From: Glen Hewlett
Sent: 22 January 2021
To: Amber Willard
Subject: Re: FP/231/20/PL

Re: FP/231/20/PL

I am the case officer on an application at Abergail, Clyde Road. FP/231/20/PL

PROPOSED ELEVATIONS

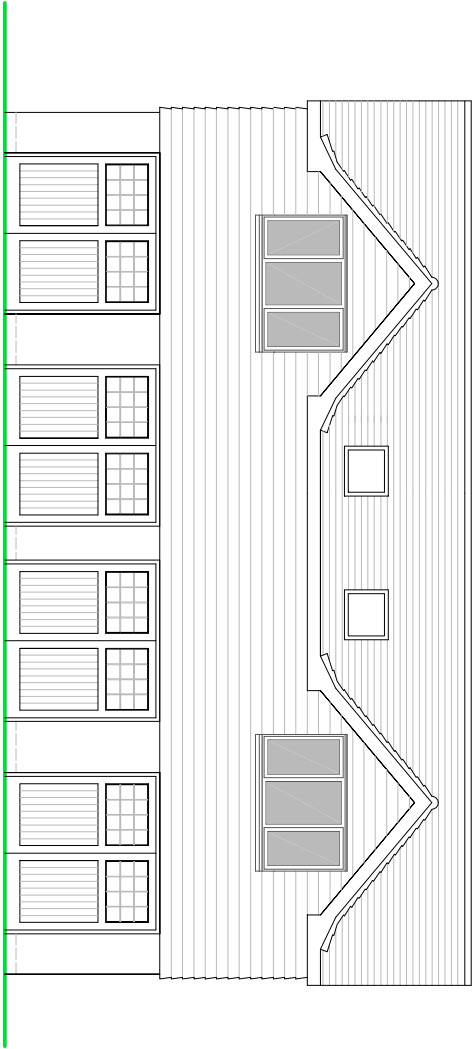
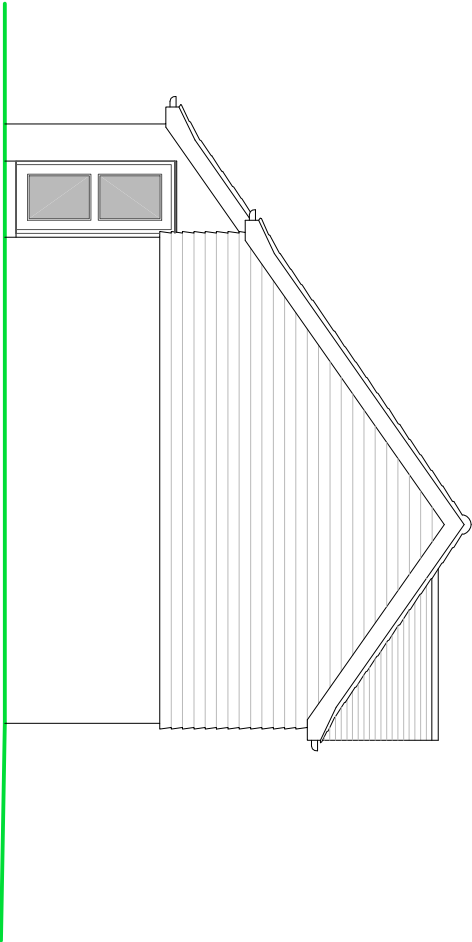
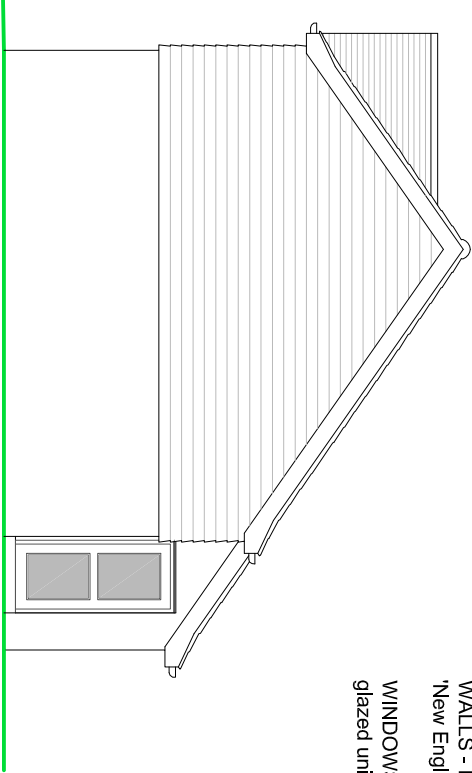
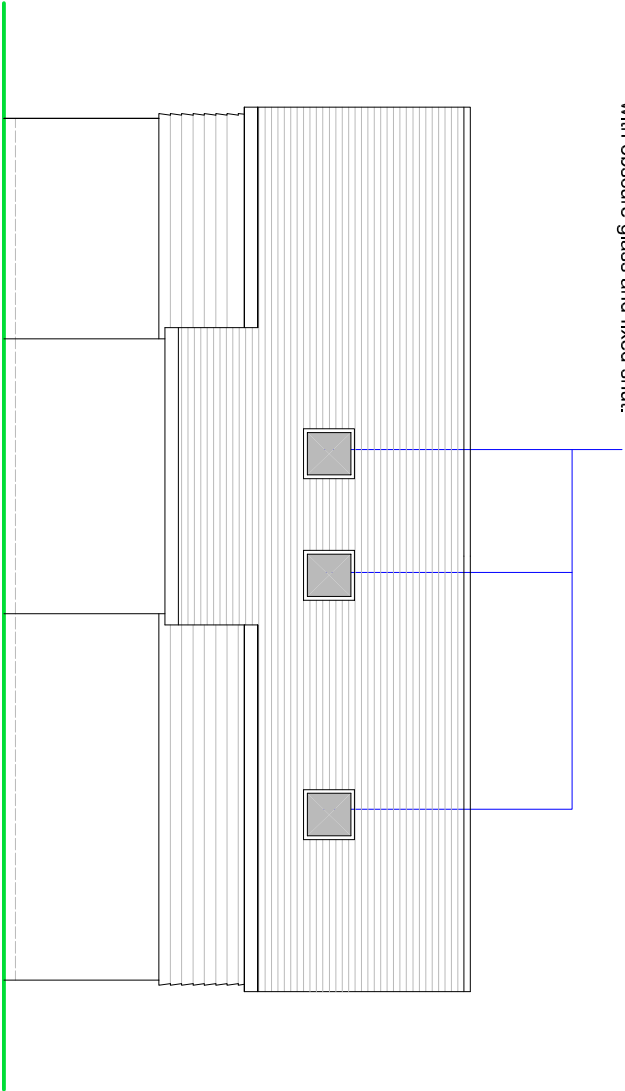
I can confirm that following the modified drawings being submitted by the applicant which shows a 1m separation at first floor level in accordance with ADC policy DM4 Felpham Parish Council is happy to withdraw its objection to the original application. I have also left a message to this effect on the voicemail at ADC.
